Red Text = The El Paso County Comments Rev. 1

Green Text = The Engineer of Record answers on the El Paso County Comments Rev. 0 for Variance of Use project

1185 N Curtis Rd, Colorado Springs, CO 80930

PROJECT NAME:
**VARIANCE
OF LAND USE**

SHEET NUMBER:  
**S-1**

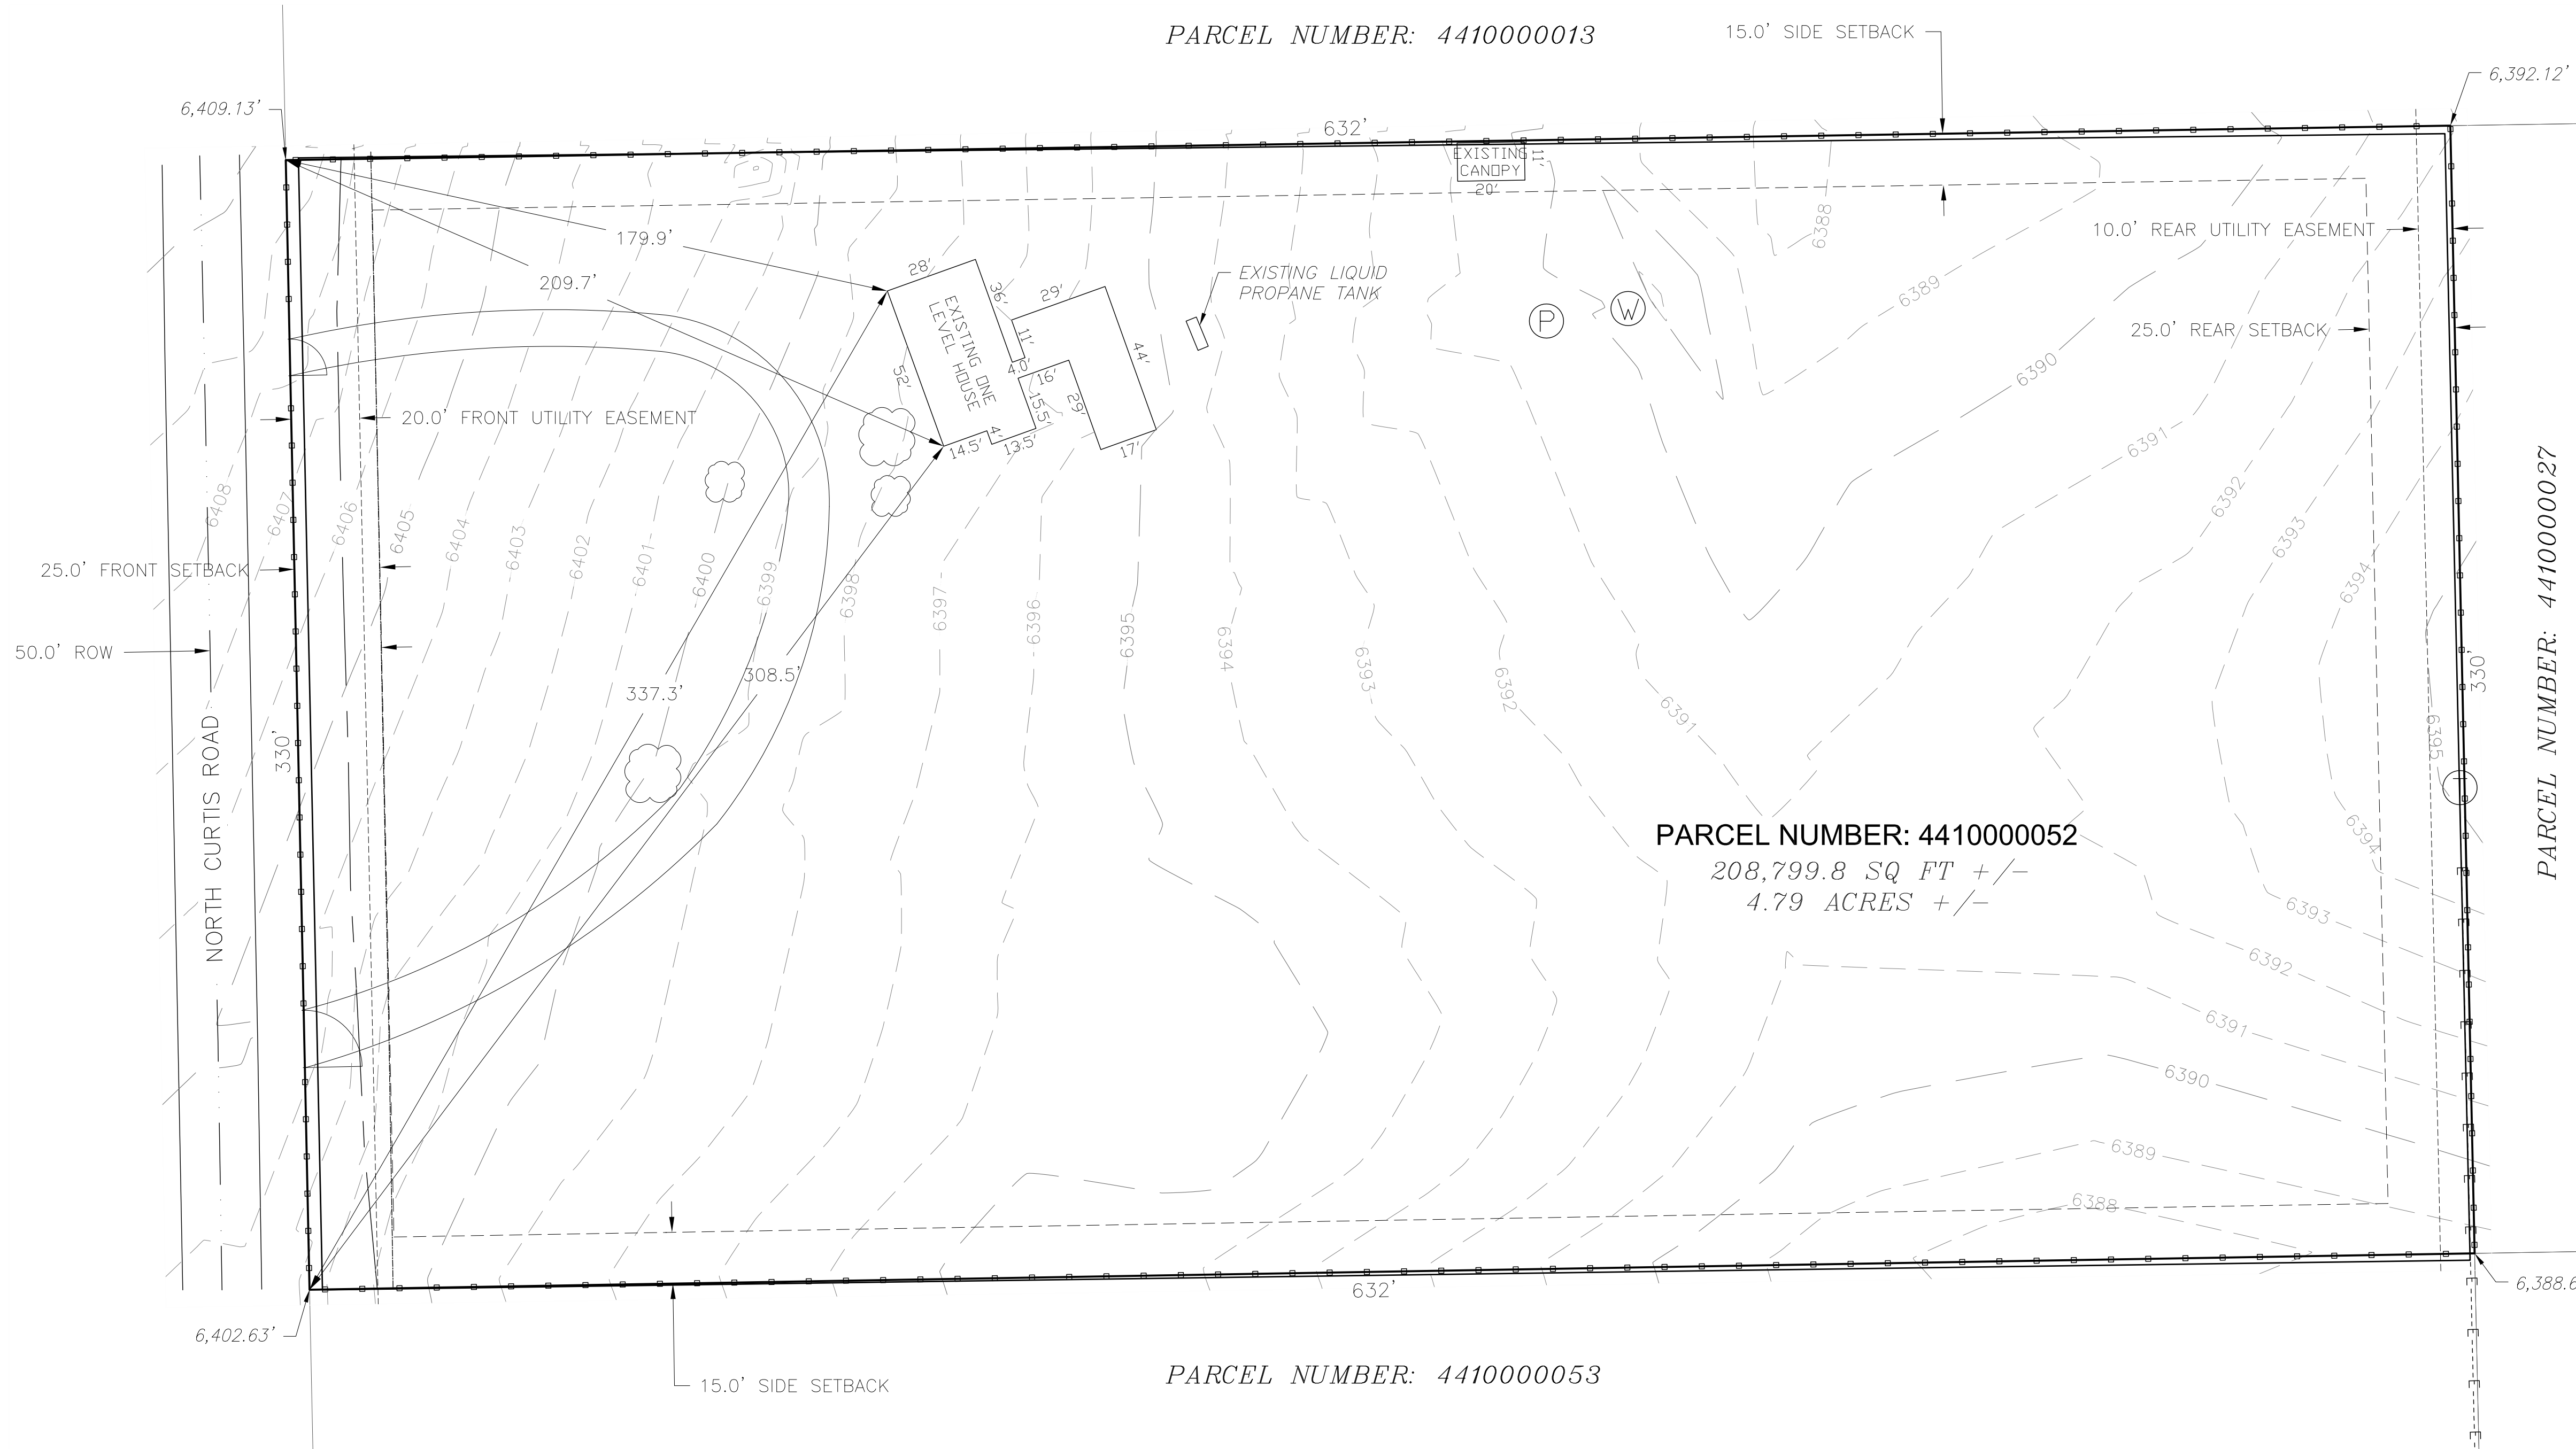
1. If there are no no-build areas or floodplains please specify
✓ There are no no-build areas or floodplains.
2. What is the setback distance
✓ The side setback distance is 15 feet. The Existing Canopy seats at the location as presented on Sheet #: S-1 before the client purchased the property. By the way, this structure will be moved to the new location as presented on Sheet #: S-2 with respect to the side setback.

**SHEET NUMBER:**  
**S-2**

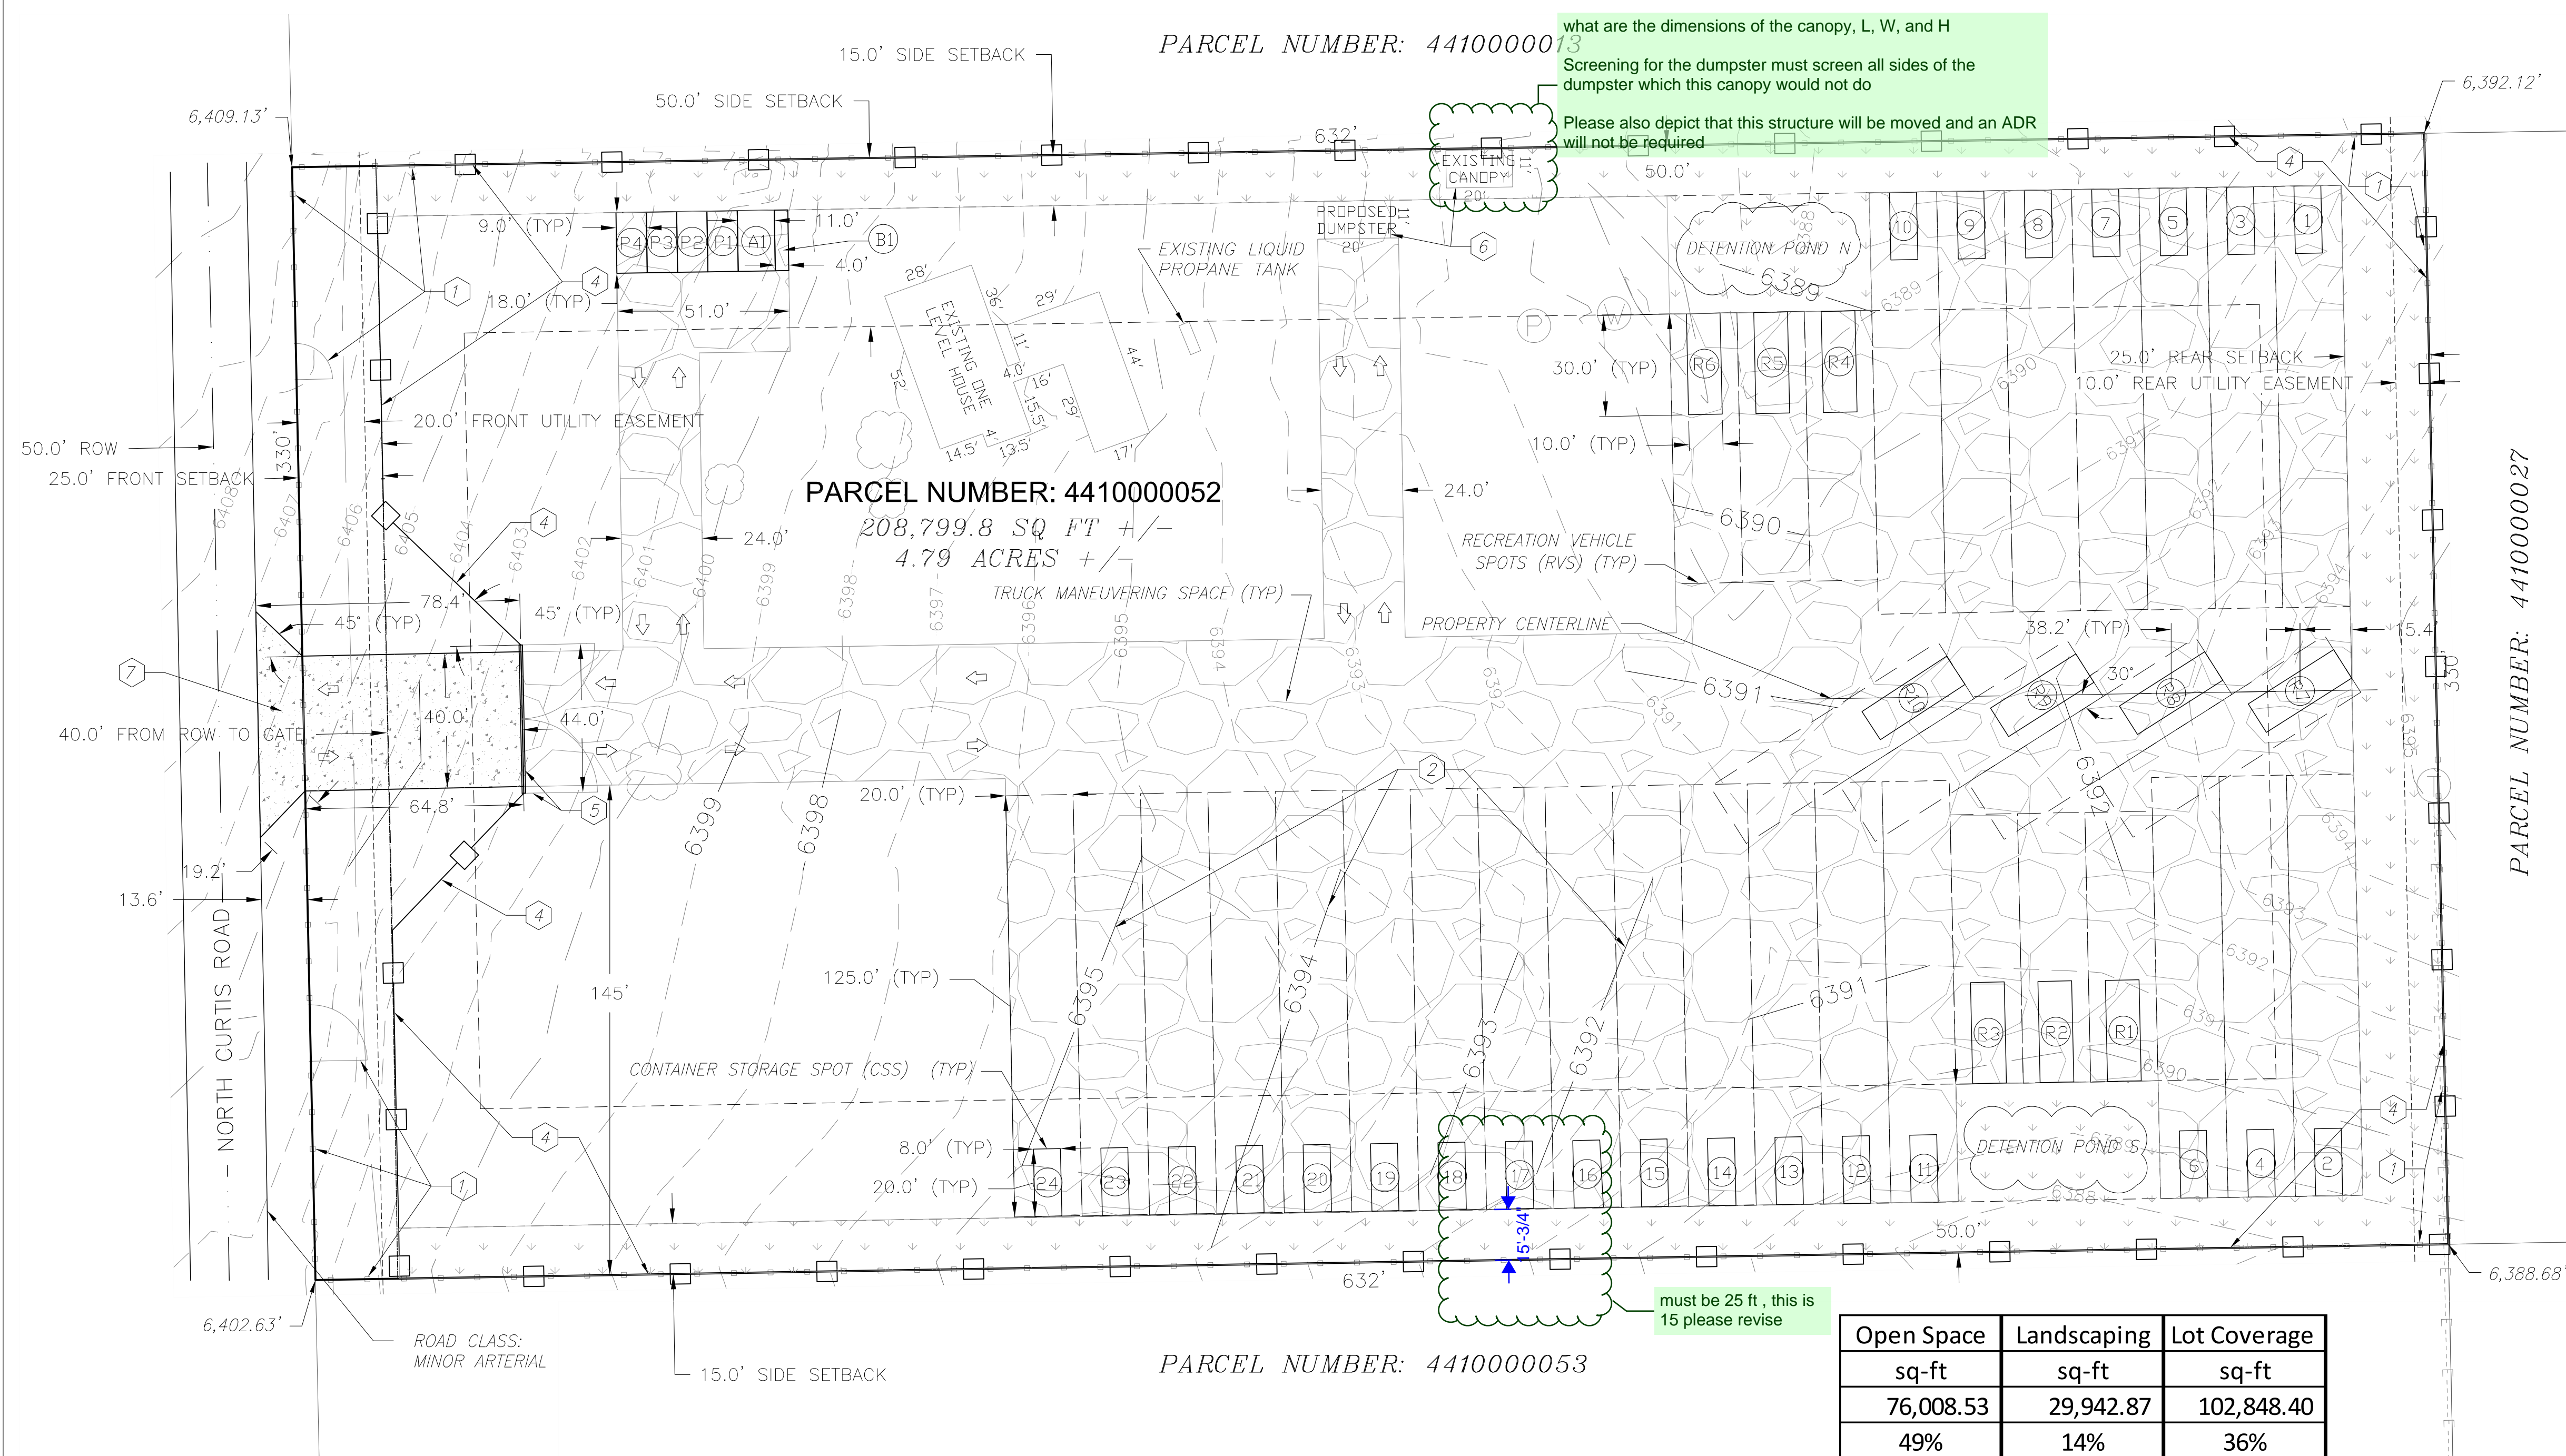
3. What type of screening is going to be used?
✓ The proposed dumpster will have ribbed metal siding on three sides, west, north, and east, as presented on Sheet #: S-2 – Schedule No. 6.

4. These structures need to be 25 ft setback
✓ The side setback is 15 feet. Therefore, there is no need for corrections.
5. Please provide 1 bicycle space Section 6.2.5.F.1
✓ Corrected. The bicycle space is provided as presented on Sheet #: S-2.

7. 2 way commercial entrance to an arterial road min 35ft max 40ft width per ECM 2.4.1.E Please correct.
✓ Corrected, as presented on Sheet #: S-2
8. Specify material type
✓ Corrected. Please see Legend on Sheet #: S-2.

9. Call out entrance surface material type for first 50ft either asphalt mat or concrete
✓ The entrance surface material type called out is Number 7. Please see Schedule note number 7 on Sheet #: S-2.

10. Note: If the site will be unmanned with a 24/7 access gate. The entrance and gate should be set back further to ensure no long RVs or truck are sticking out into the road as they stop to open the gate. If two vehicles arrive at near the same time the current design does not have a provision for parking or staging off the roadway. With the gate set back 30ft from the ROW the longest vehicle could be ~37ft or it stick out into the ROW.
✓ Corrected. The entrance gate is set back 40 feet from ROW.

✓ There is a very low probability that two vehicles arrive at the same time and the gate is closed. If that happens, they still have the opportunity to park side by side at the entrance driveway since that is 40 feet wide and more than 78 feet long.
